Our Ref: CC/2205771

13th November 2024

F/15/24/RES & F/14/24/RES – Land at Ford Airfield, Ford, West Sussex

Basin Section Part A
1:100

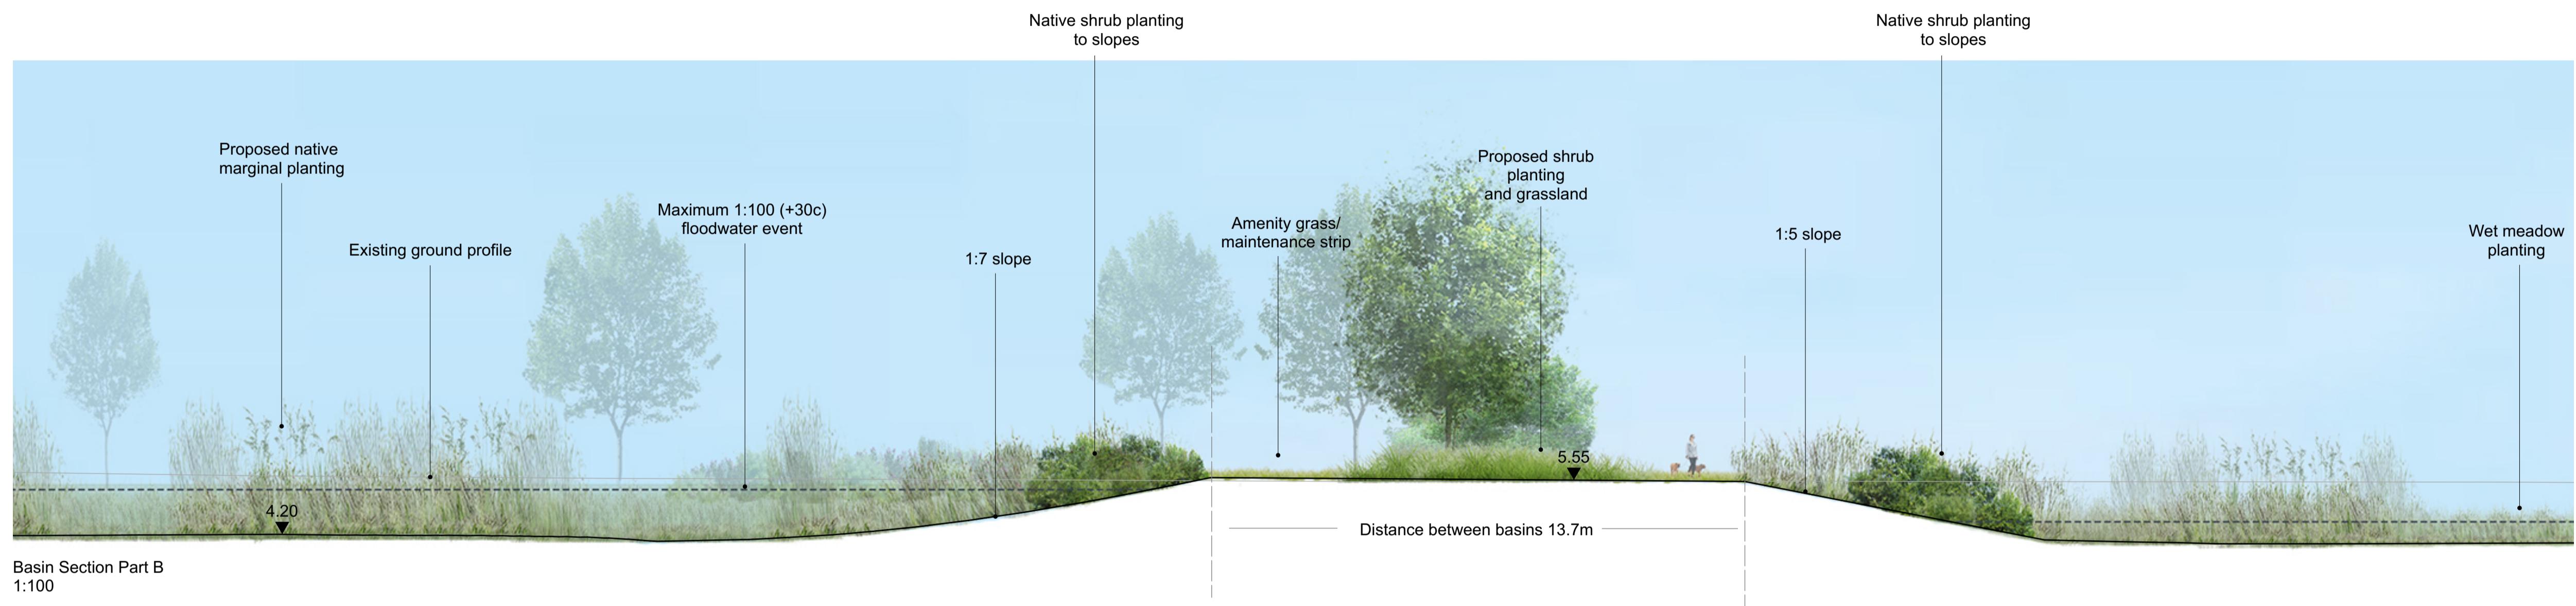
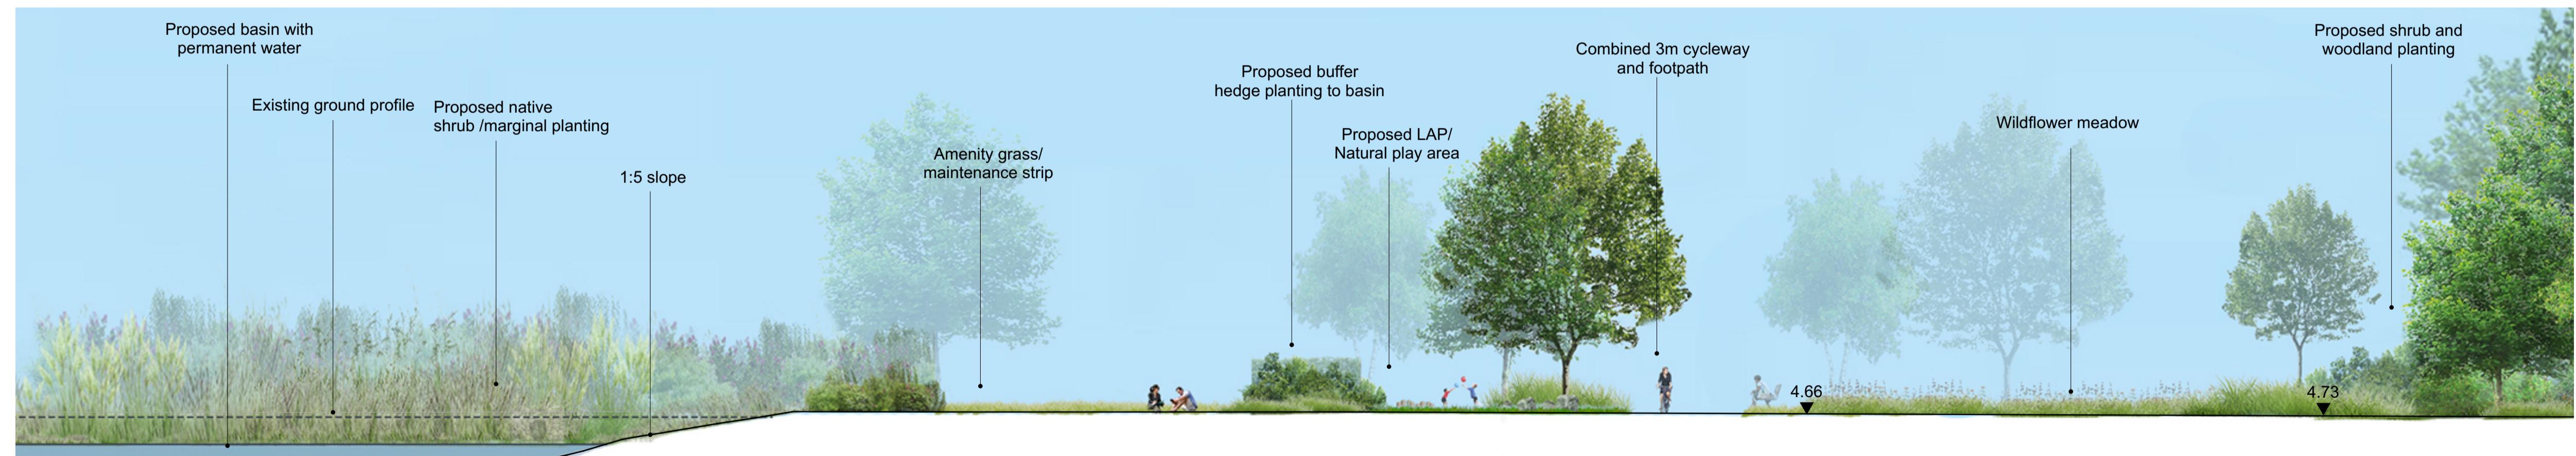
2. The high groundwater levels will also need to be considered in detailed design of attenuation structures. 1m buffer (finished level and water level)

7. Easements 3m from the top of the bank on both sides of any watercourses and the basins are required for maintenance access. Off road parking for maintenance vehicles is also required. Updated plans should reflect these requirements and be sufficiently and clearly annotated.

Please refer to response to Point 1. The detailed design will give consideration to the groundwater level and SuDS features will be appropriately lined where required.

This is provided as annotated on applicable plans as hashed lines around each drainage feature - we will ensure this is made clearer by adding a note(s) to the plan. Parking for maintenance vehicles is available within the maintenance strip which is more practical for access and vegetation removal.
